Application Ref:	3/2025/0724			 Ribble Valley Borough Council www.ribblevalley.gov.uk				
Date Inspected:	3/10/25	Site Notice:	3/10/25					
Officer:	BT							
DELEGATED ITEM FILE REPORT:					APPROVAL

Development Description:	Erection of three-storey dwellinghouse with attached two-storey coach house adapted from existing structure. Planning permission previously granted (3/2024/0248) for similar sized house, existing house already demolished, and foundations for the accepted proposal have already been built.
Site Address/Location:	Hawthorn Bungalow, Rimington Lane, Rimington, BB7 4DP.

Ben Pentreath		1-4 Lamp Office Court Lamb's Conduit Street London WC1N 3NF T +44 (0) 20 7430 2424 benpentreath.com
PROJECT:	HAWTHORN, RIMINGTON	
TITLE:	PROPOSED ELEVATIONS 1:100 @ A1	
DRAWING NO:	HWTN-A-200	REV. NO: P
SCALE:	1:100 @ A1 1:200 @ A3	DRAWN BY: SC
DATE:	05/09/2025	CHECKED BY: RC

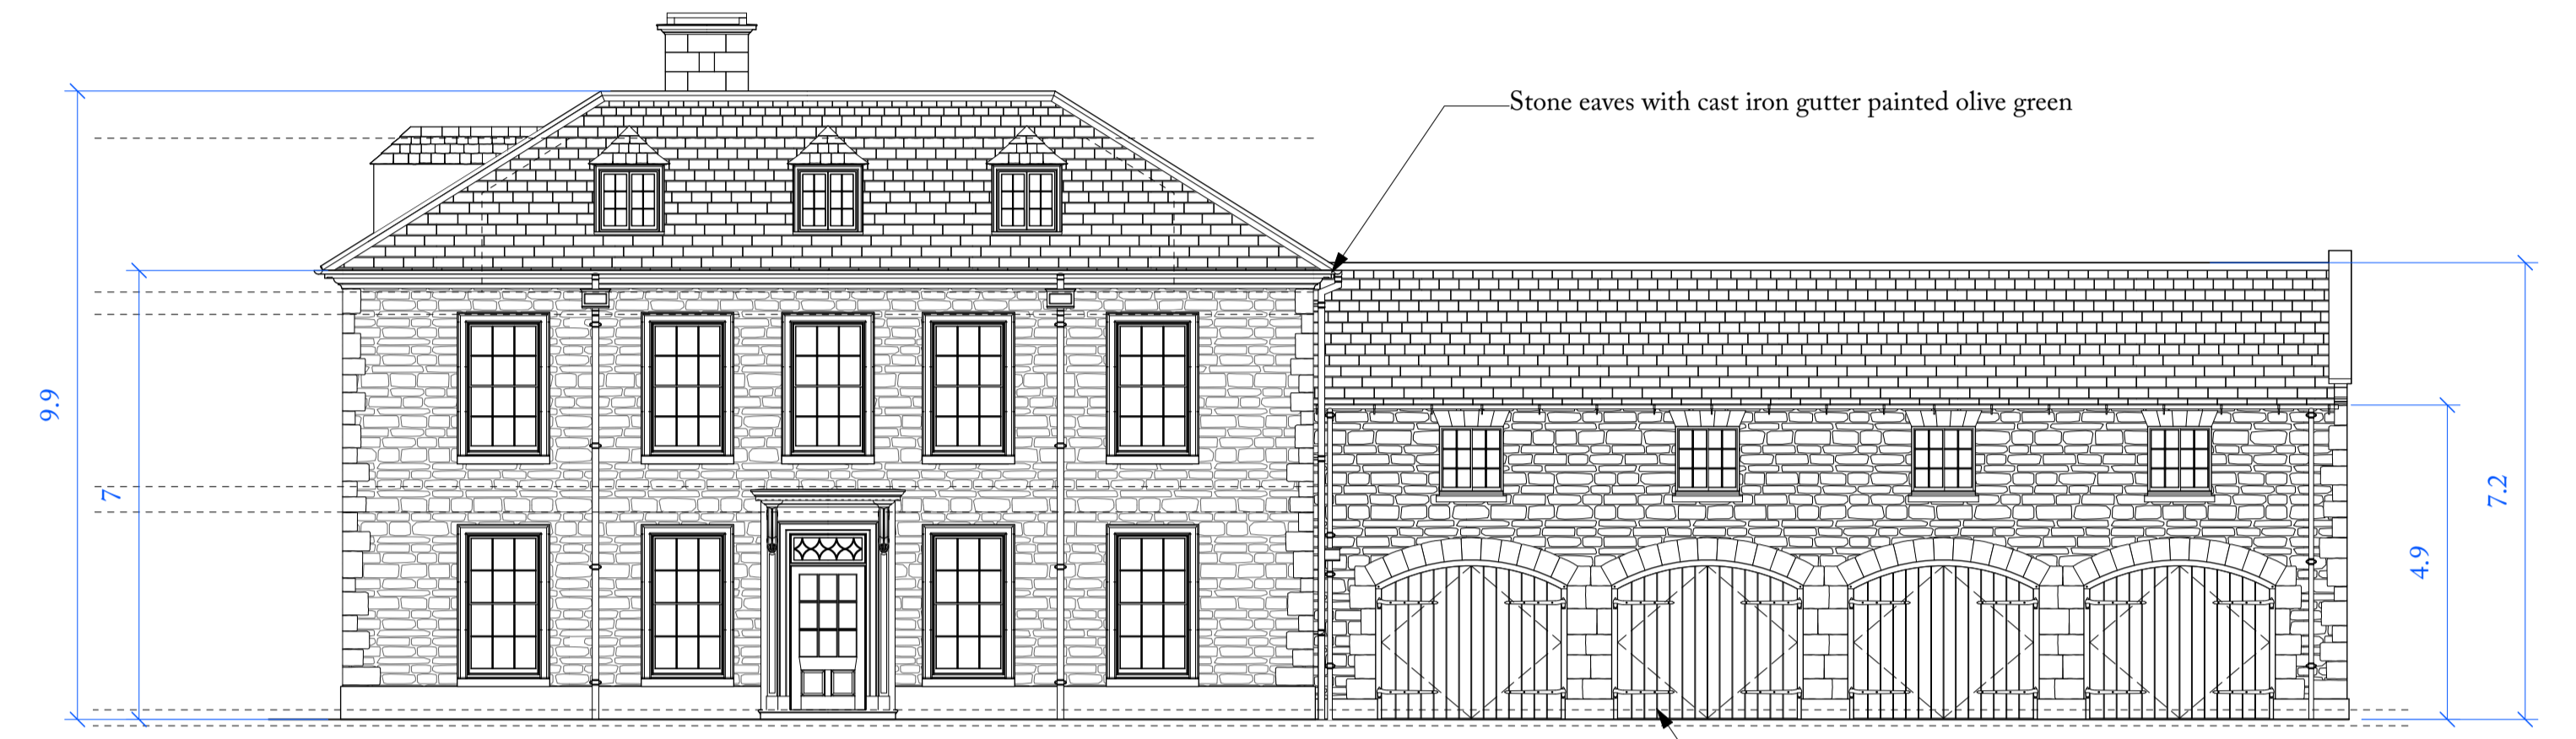
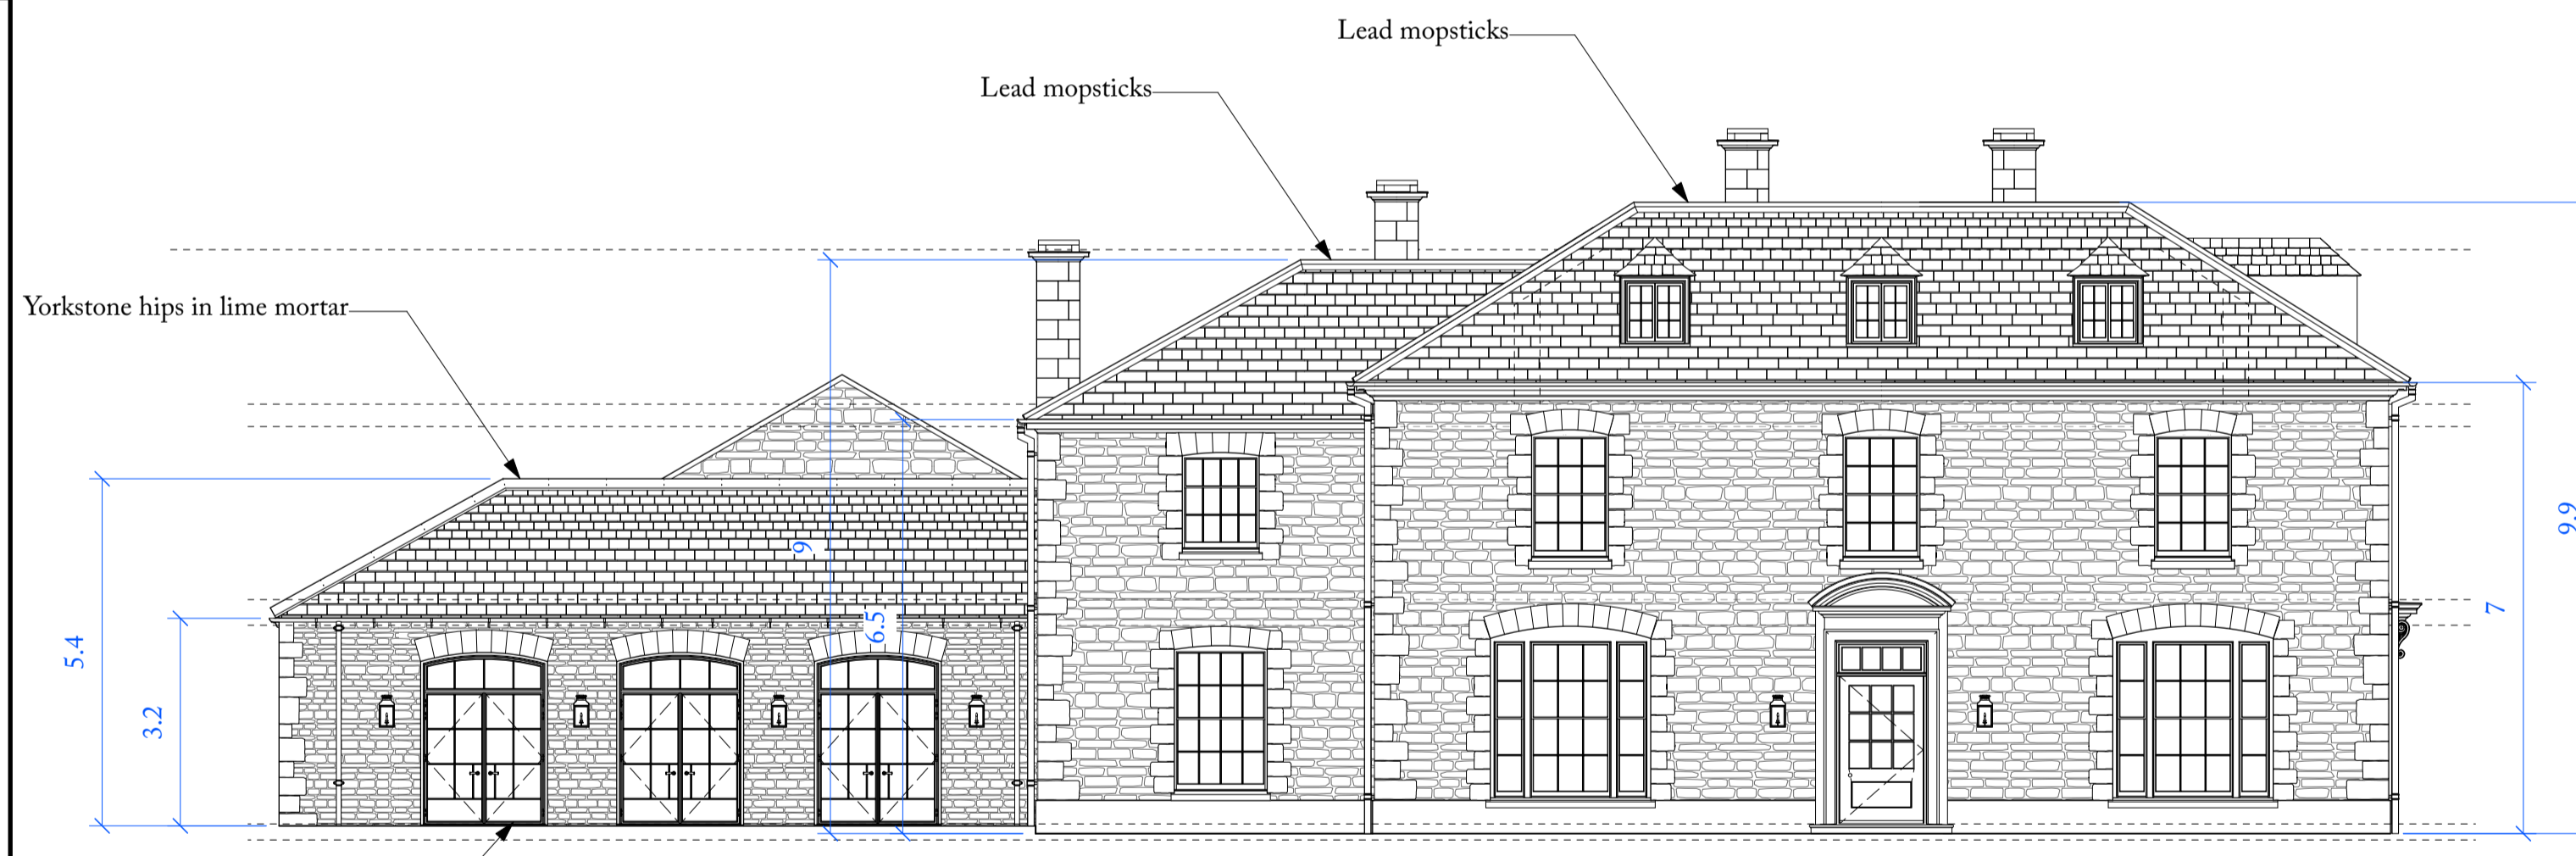
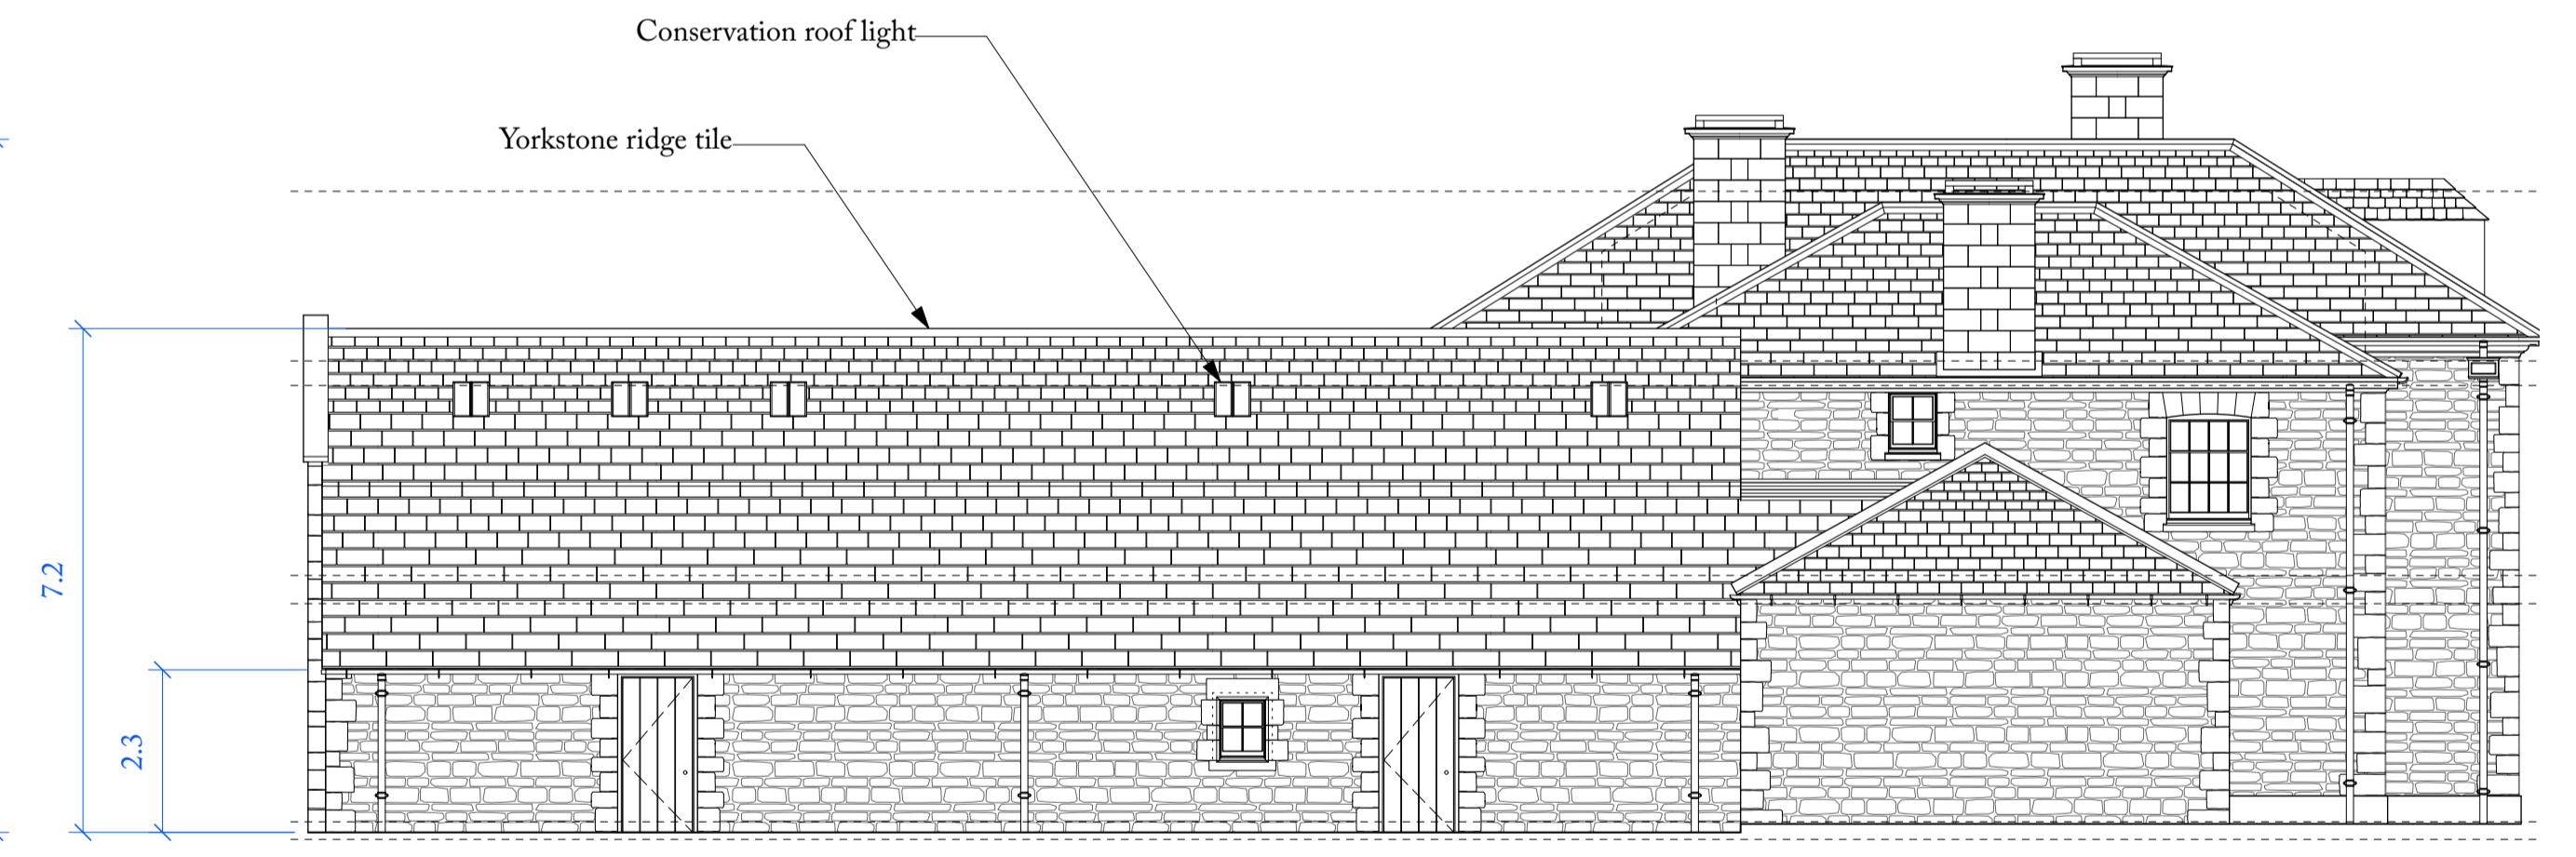
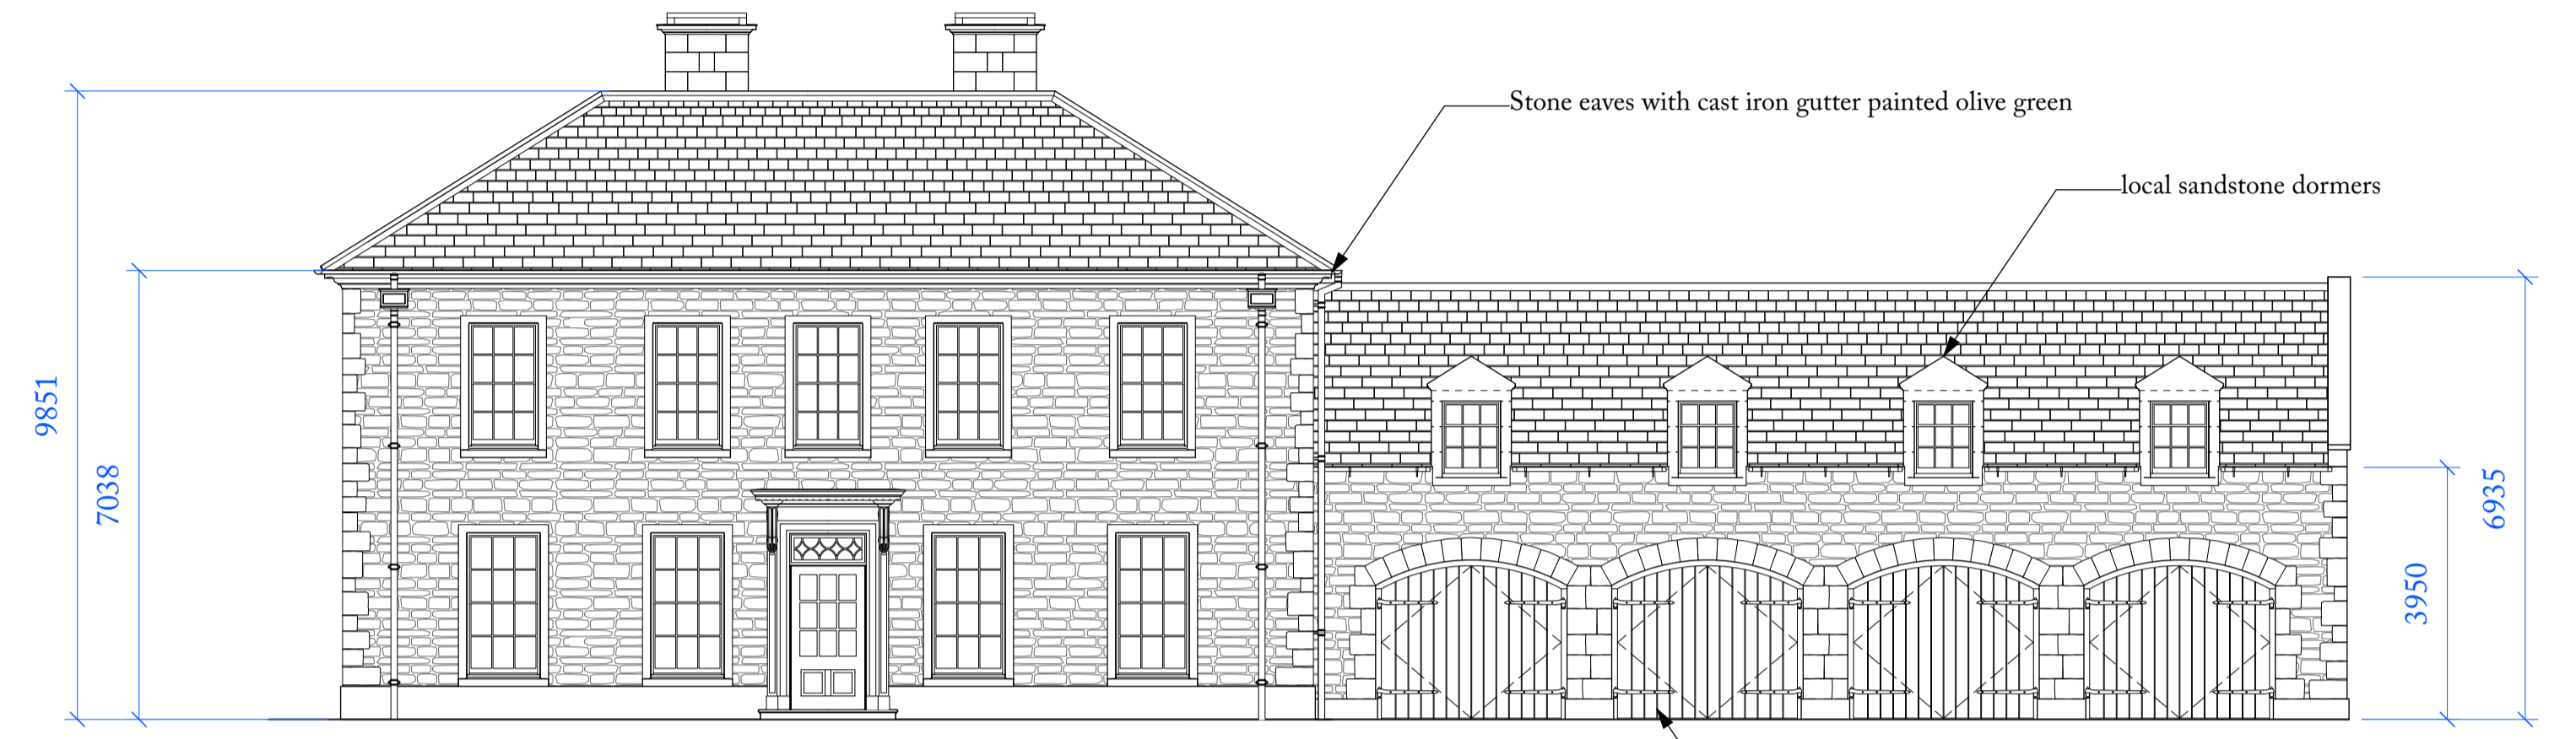
In this instance, the design of the proposed replacement dwelling as originally submitted comprised a sizeable two storey link element between the main house and its kitchen / living / dining room and boot room components. A sizeable integral garage component was also proposed initially with the Eastern facing eaves height of this structure comprising a height of just under 5 metres. These features were considered to be over dominant and unsympathetic additions to the main dwellinghouse by virtue of their bulk, massing and height, both of which were noticeably larger than the link and garage elements approved under previous application 3/2023/0660. In addition, numerous dormer and chimney features were proposed initially which were also considered to be unacceptable additions on the basis that these features would further exacerbate the bulk and massing effect of the proposed development. Further concerns were also raised with regards to the original sequence of fenestration proposed for the Southern and Eastern elevations of the dwellinghouse with respect to window quantities and proportions.

Following extensive negotiation an amended proposal has since been submitted with the principal elevation of the proposed link extension stepped back from the principal elevation of the main dwellinghouse and with

the floorspace within the upper level of the dwelling's integral garage component reduced, with these changes having subsequently created a clear visual break between the dwelling's link and garage components. Dormer windows have also been added to the upper level of the dwelling's integral garage component which in turn have facilitated a reduction to both the eaves and ridge height level of this structure. The dormer features previously proposed for the Southern and Eastern roof slopes of the dwelling have also been omitted from the proposal. These changes have resulted in a noticeable reduction to the bulk and massing effect of the proposal and as such are considered to be acceptable. In addition, reductions have been made to the width and height of the window openings proposed for the dwelling's Eastern elevation with a simplified design also incorporated to the architraves and door surround within this elevation. Furthermore, the proportions of the ground floor tripartite window openings within the Southern elevation of the dwelling have also been reduced. These changes have resulted in a more balanced sequence of fenestration and are therefore considered to be acceptable. The proposal seeks to retain five chimney features within the roofspace of the dwelling (omitting only one from the original scheme) however on balance the chimney features are not considered to be excessive in terms of size and would be evenly distributed across the roofspace of the dwelling. As such, the retention of these features within the proposed development is considered to be acceptable.
